# Proposed SHD St. Joseph's House and Adjoining Properties

**Quality Audit**

<b>1.1</b>	<b>Title</b>	<b>ST. JOSEPH'S SHD QUALITY AUDIT</b>
<b>1.2</b>	<b>Audit Reference Number</b>	<b>ST. JOSEPHS QUALITY AUDIT MA 315</b>
<b>1.3</b>	<b>Project Code</b>	<b>BERWICKPINES</b>
<b>1.4</b>	<b>Date Audit Completed</b>	<b>14<sup>th</sup> May 2021</b>
<b>1.5</b>	<b>Audit Attended By</b>	<b>Ludmila Santos</b> <b>Mark Andrews</b>
<b>1.6</b>	<b>Audit Team</b>	
	<b>Team Leader</b>	<b>Mark Andrews, ILTP</b>
	<b>Team Member</b>	<b>Ludmila Santos, ILTP</b>

BASEMENT 1 + 3 LAYOUT PLAN 1:200

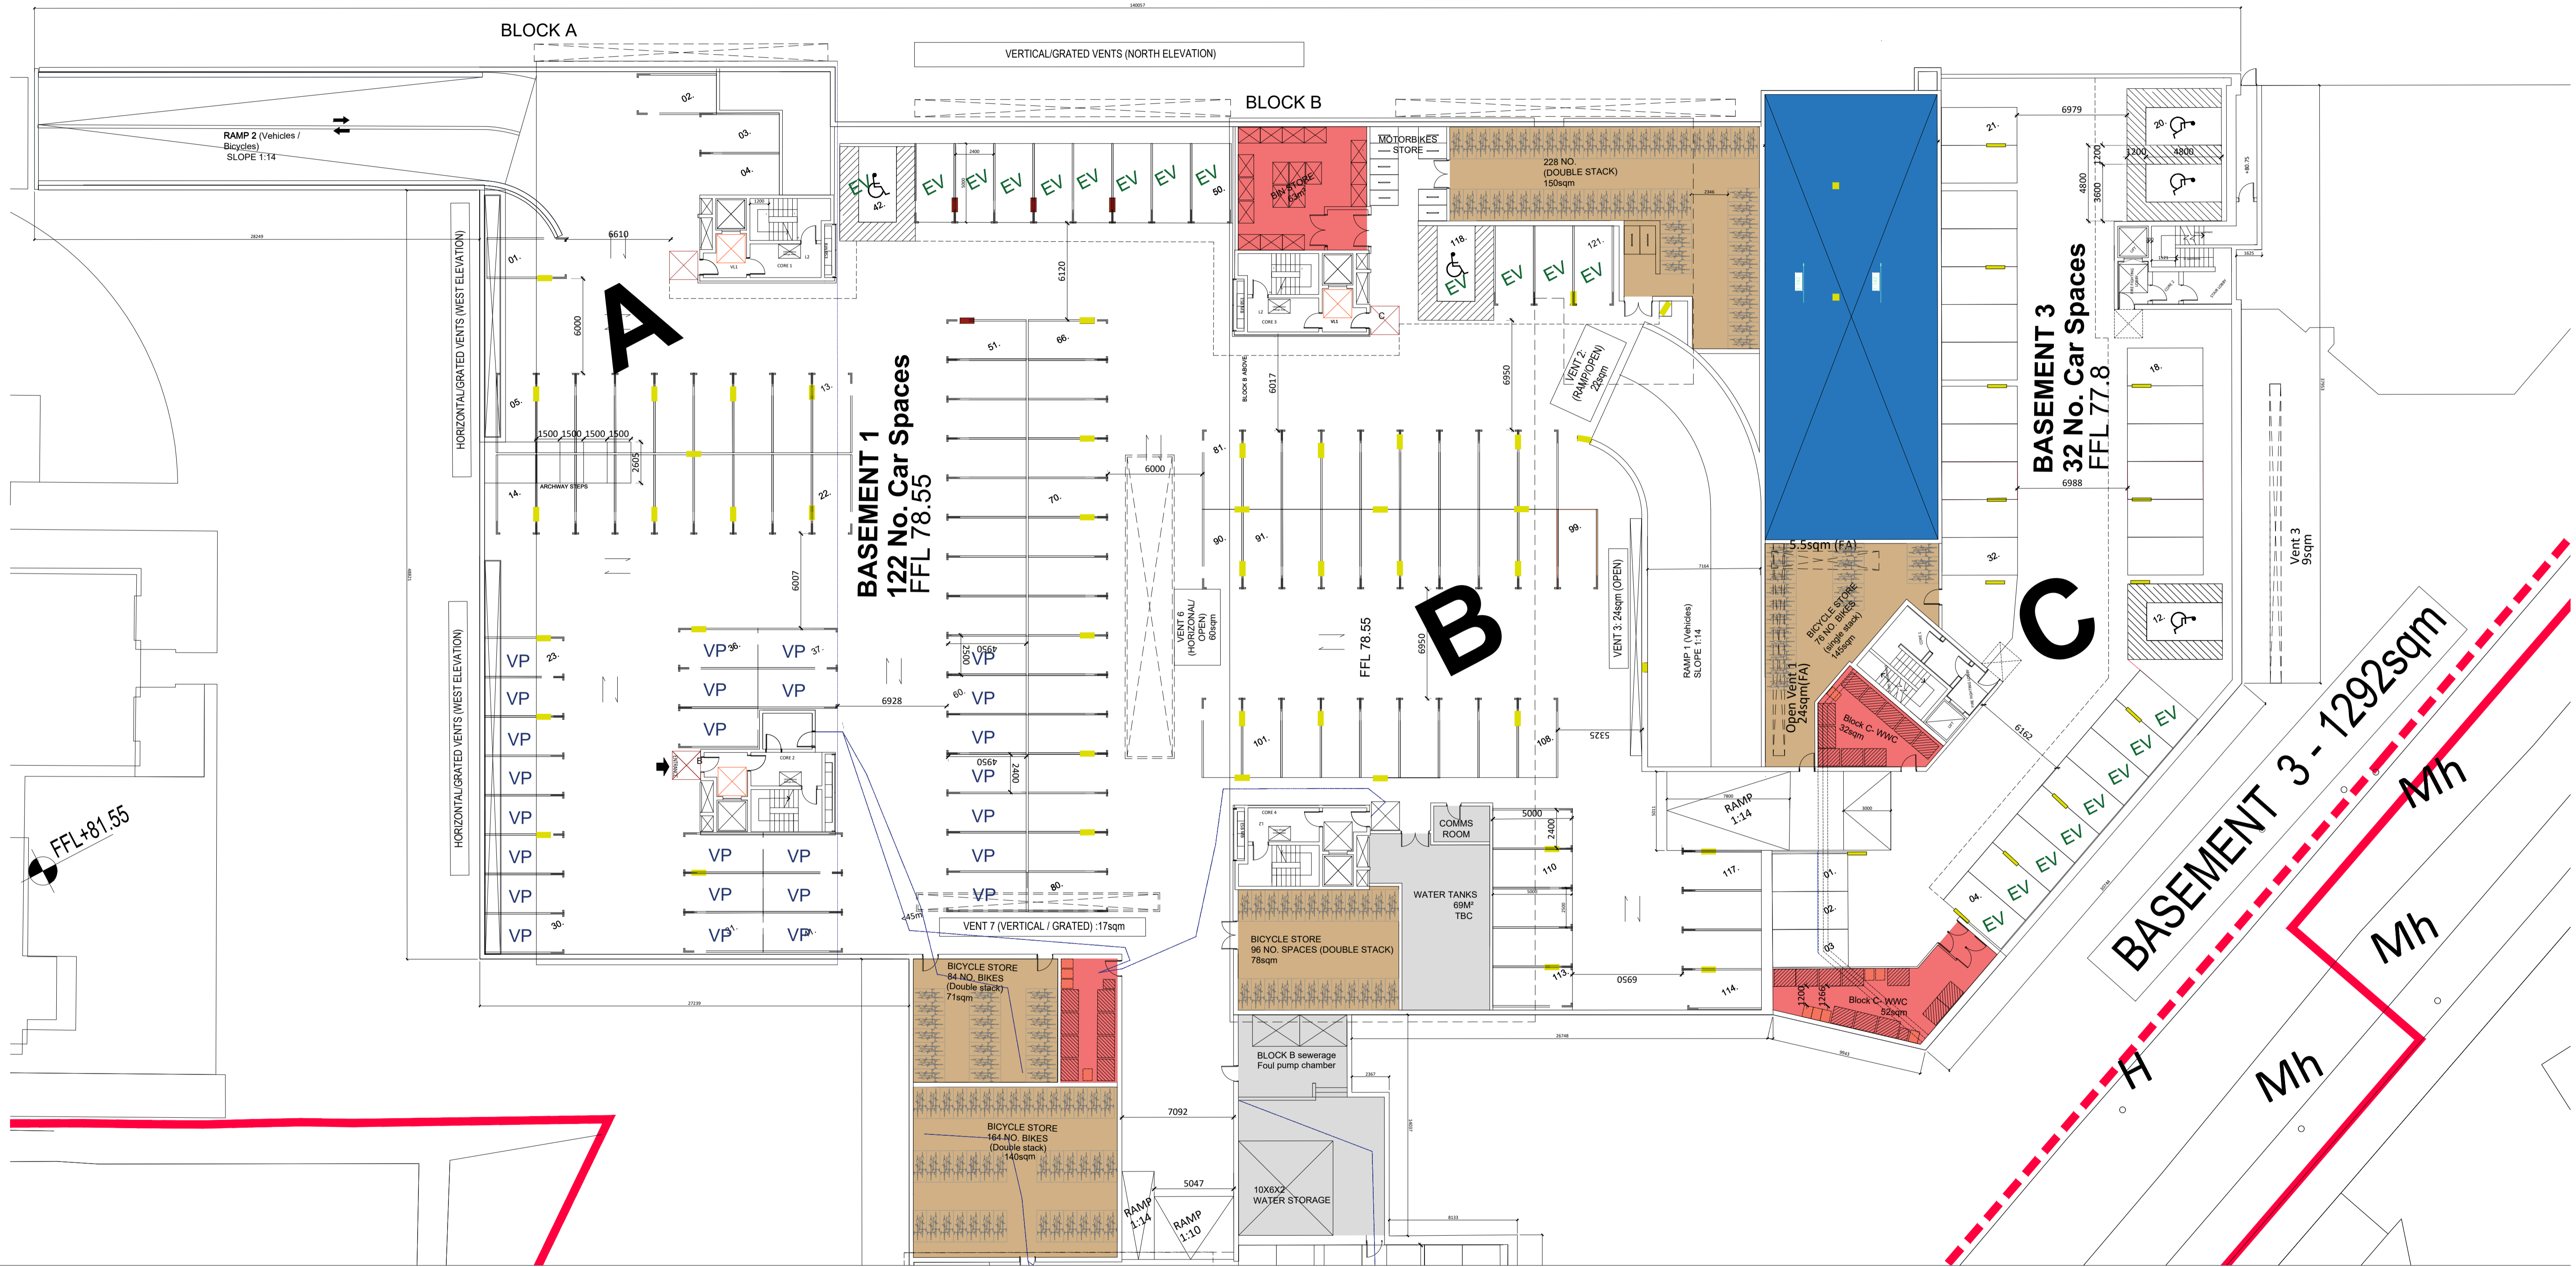
The drawings provided for audit do not include details of pedestrian walkways at basement level to facilitate pedestrian movement along designated routes.

The drawings submitted to the auditors do not show the extent or location of visitor car parking in the basement car park.

<b>Para No. in Report</b>	<b>Recommendation Accepted (Y/N)</b>	<b>Comments / Alternative Measures (Describe)</b>	<b>Alternative Measures Accepted by Auditor? (Y/N)</b>
4.1.1	Y	Pedestrian and cycle facilities will link to the existing An Sullivan School. Also access through the proposed development will be retained for the Ann Sullivan School.	
4.1.2	Y	Pedestrian walkways at basement level will be added to facilitate pedestrian movement along designated routes.	
4.1.3	Y	Visitor car parking in the basement car park will be indicated in our drawings.
